City of Portland, Maine - Building or Use Permit Application
389 Congress Street, 04101 Tel: (207) 874-8703, Fax: (207) 874-8716

DATE: 19 MAY 2001 ADDRESS: 85 Maggie Lane CBL: 342-A-024

REASON FOR PERMIT: To Construct 1 Bldg. 3 units (Dwellings)

CITY OF PORTLAND, ME
BOCA 1999 Plan Review Record
One and Two Family Dwelling

Drawing Name: Space & Bulk Requirements Lot 14
Project: MAGGIE LANE, PORTLAND

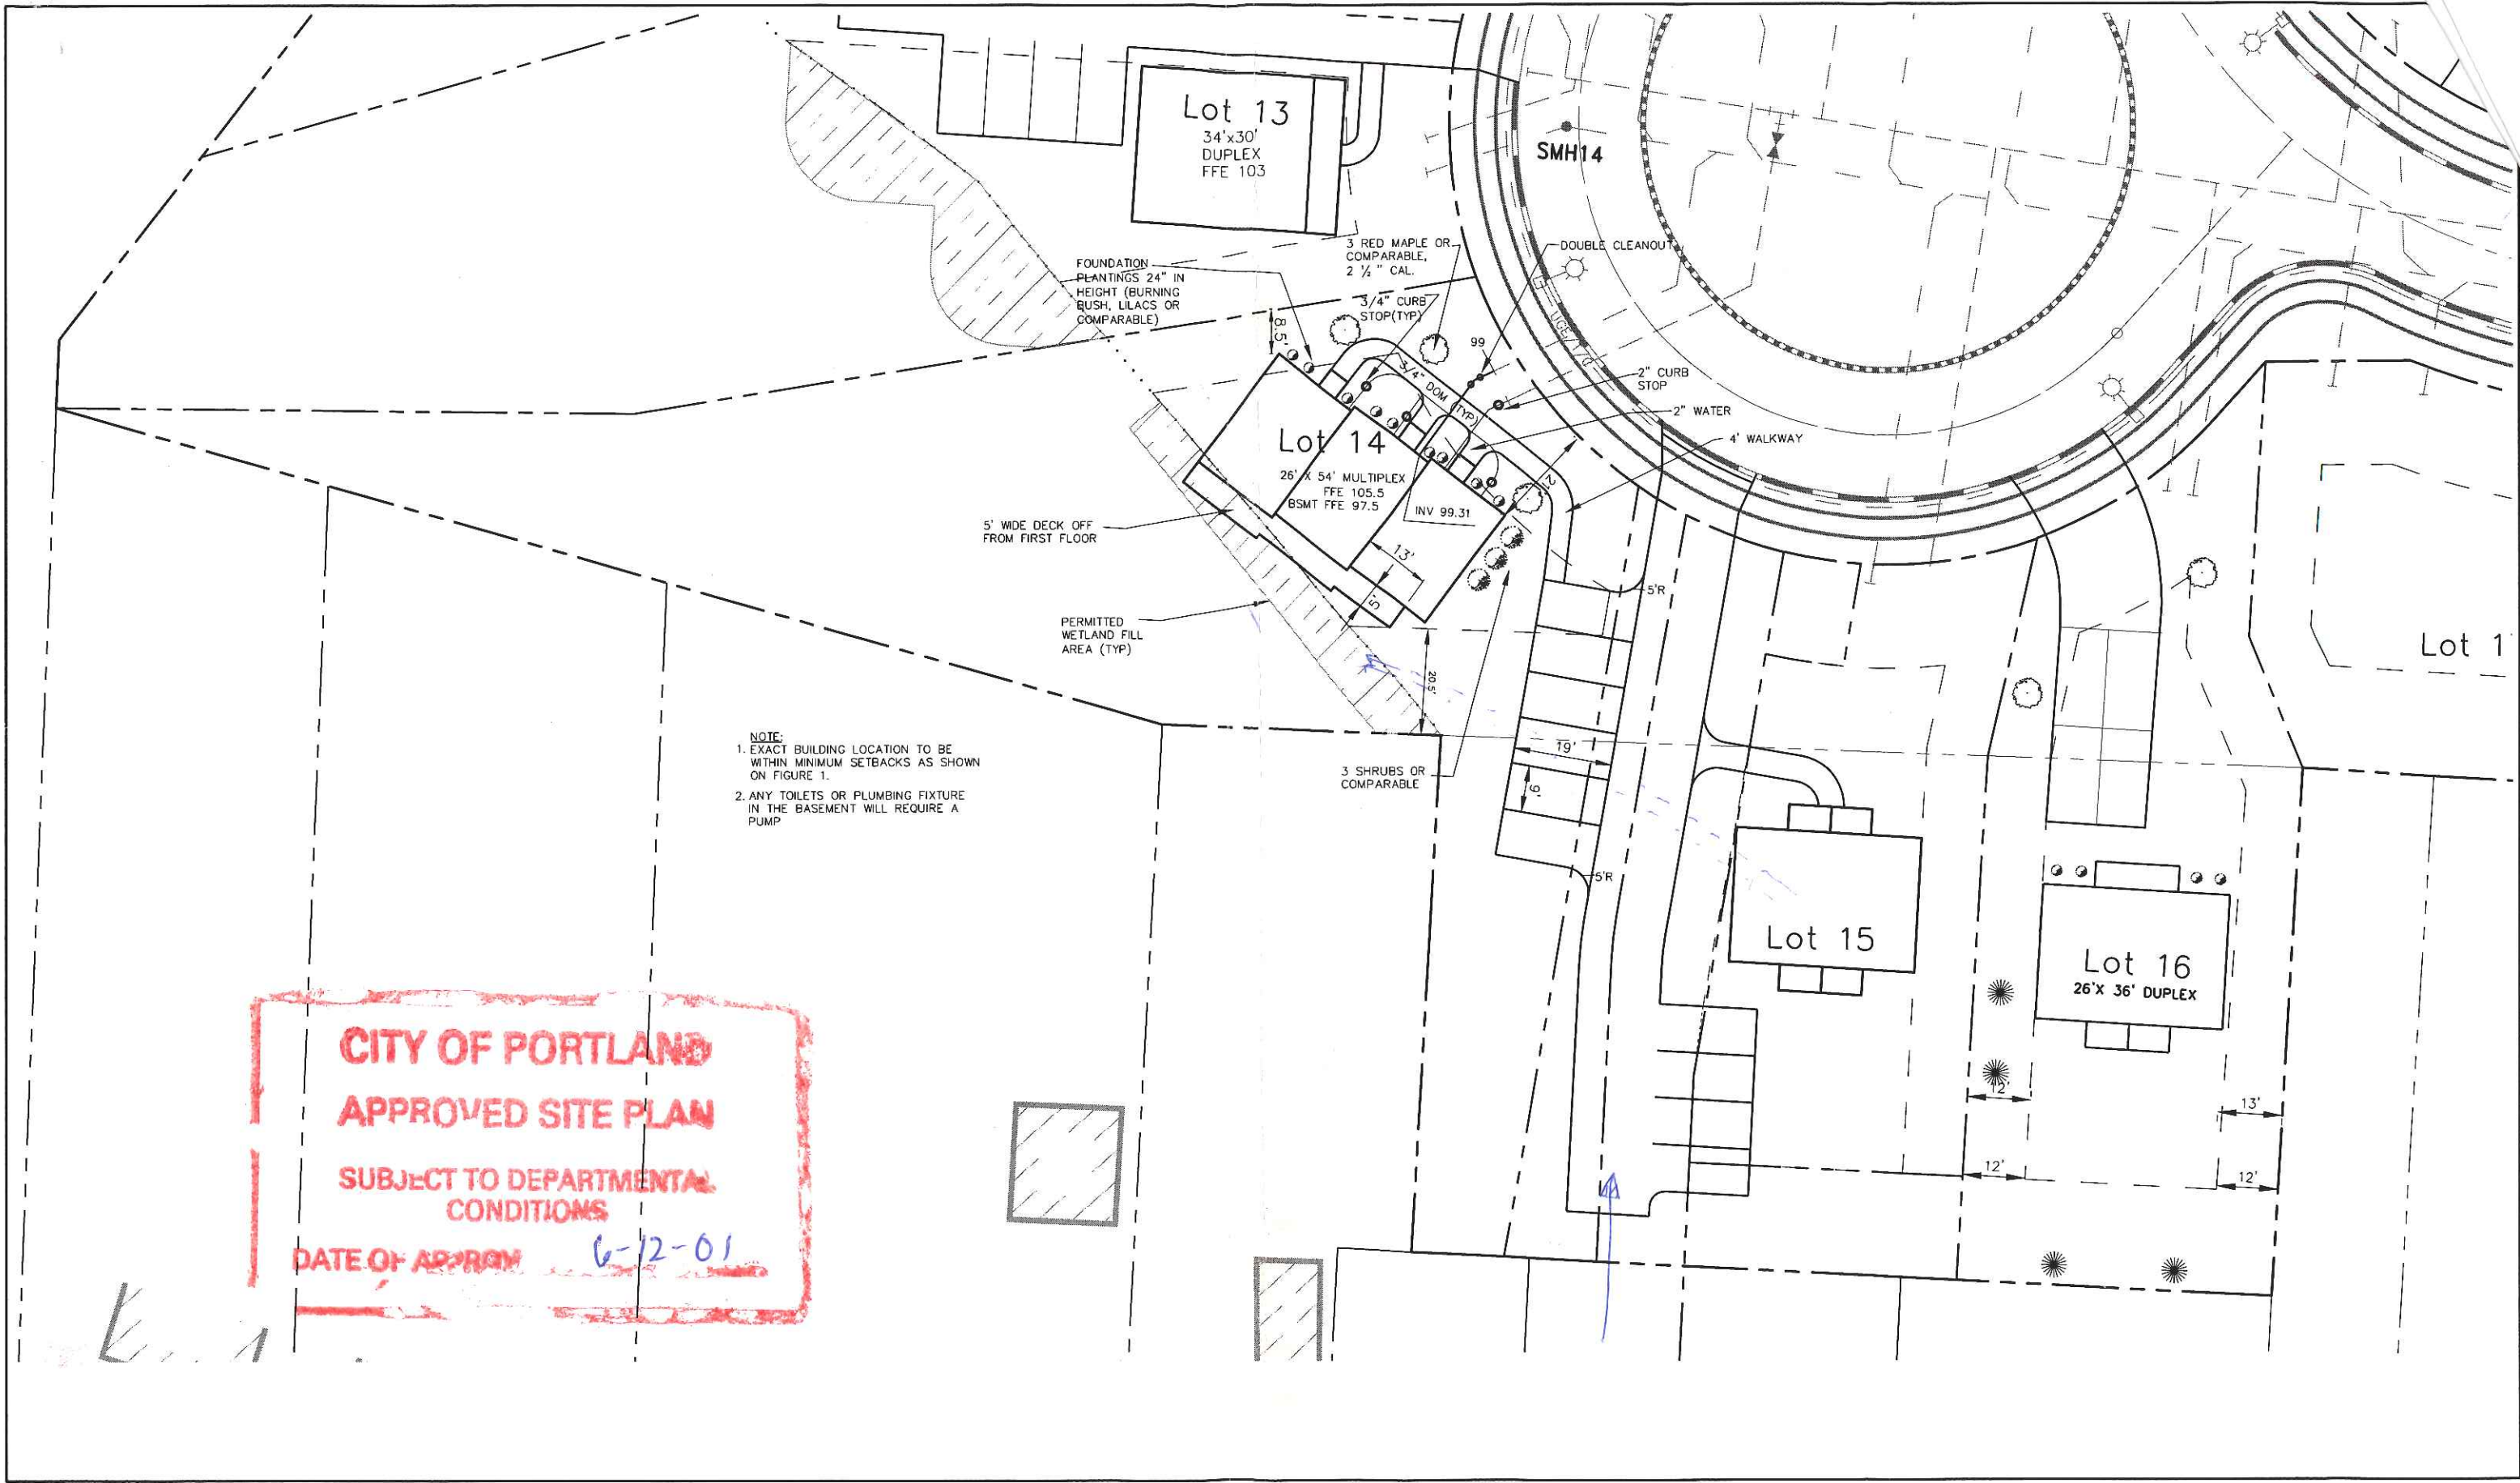
~~Old~~ Rear Yard - 20' req - ~~11' shown~~ 20.5' shown (talked to Doug Reynolds about the rear setback) received new plan 6/6

1st submittal shows the structure outside of the approved envelope

→ Note: 6/1/01 Rick Knowland gave me an e-mail saying this was OK
